Application Ref:	3/2026/0709	 Ribble Valley Borough Council www.ribblevalley.gov.uk
Date Inspected:	22/12/23	
Officer:	BT	
DELEGATED ITEM FILE REPORT:		NON MATERIAL AMENDMENT

Application Description:	Non material amendment to application 3/2023/1004 (as varied under application 3/2024/0668) involving proposed raising of the eaves and ridge height to match the recently approved development adjacent at Hunters Gate.
Site Address/Location:	The Hawthorns, West Bradford Road, Waddington, BB7 3JE.

SHEET:
PROPOSED SITE PLAN AND
STREET SCENE REVISION D

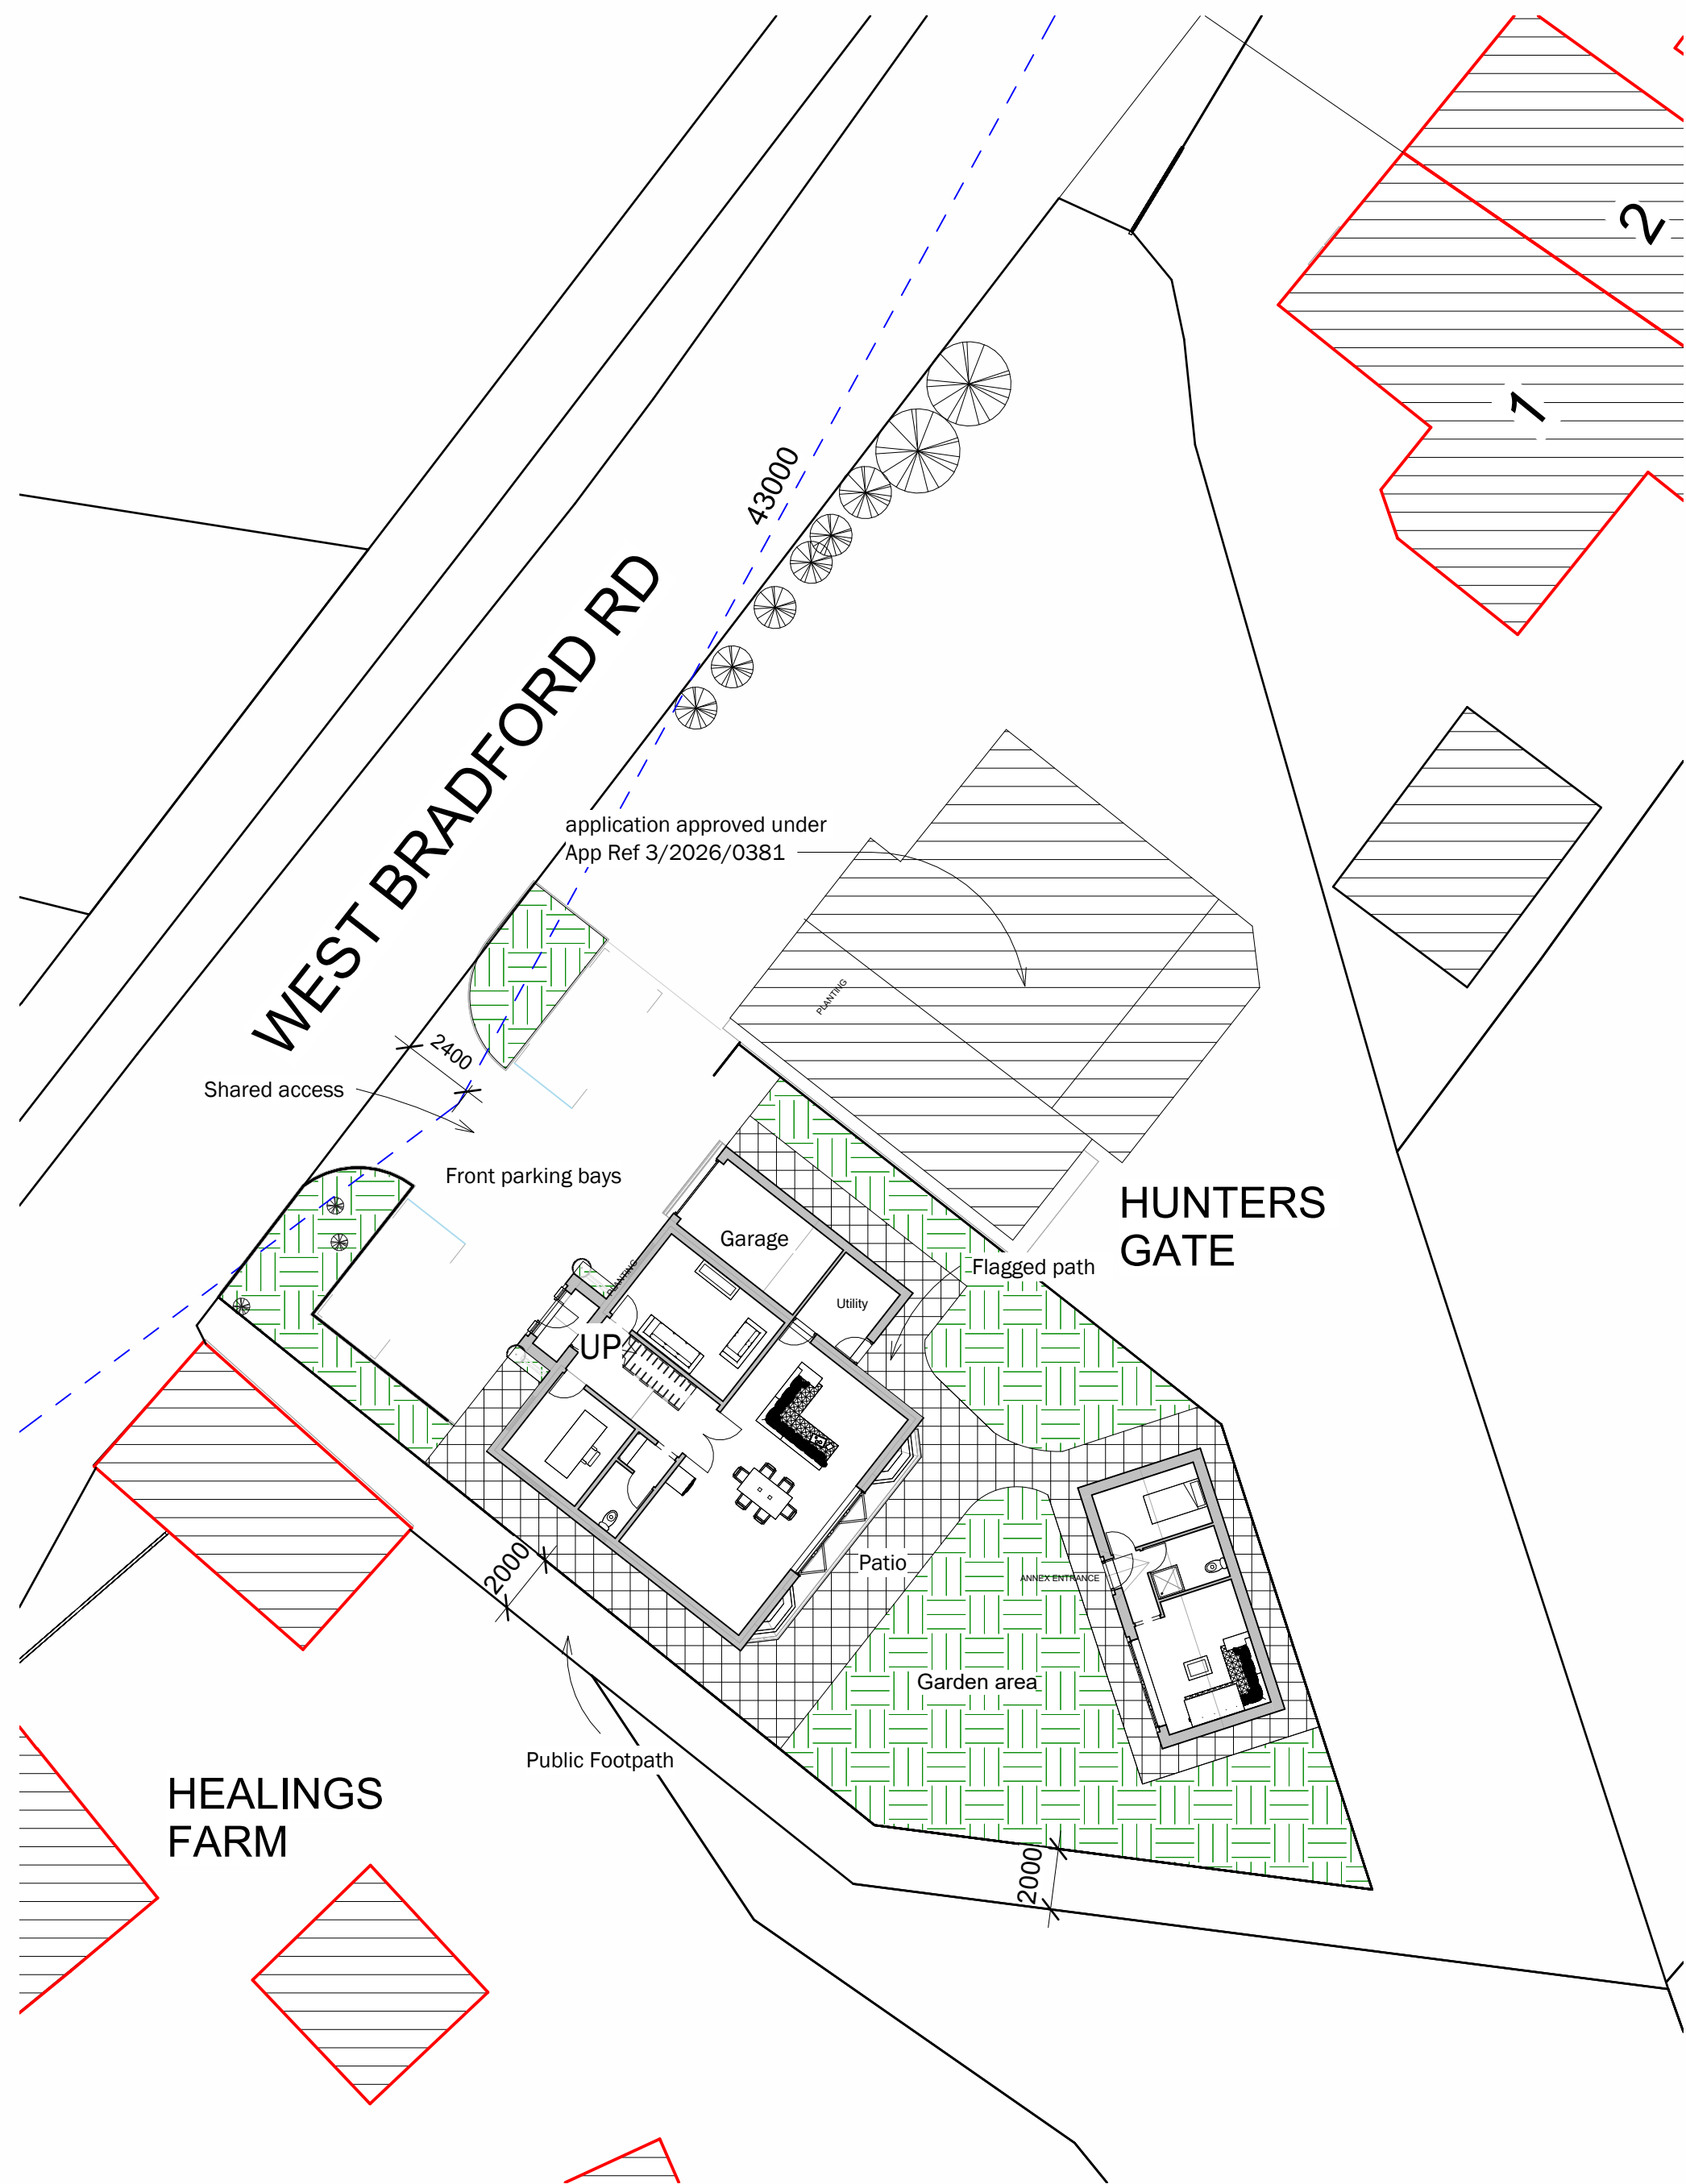
The revised street scene drawing provided in support of the application shows that the revised roof ridge line of the replacement dwelling would not result in any discernible change to the roofscape arrangement shared between the application property and adjacent neighbouring properties of No. 1 and No. 2 Greenfern, Hunters Gate and Healings Farm.
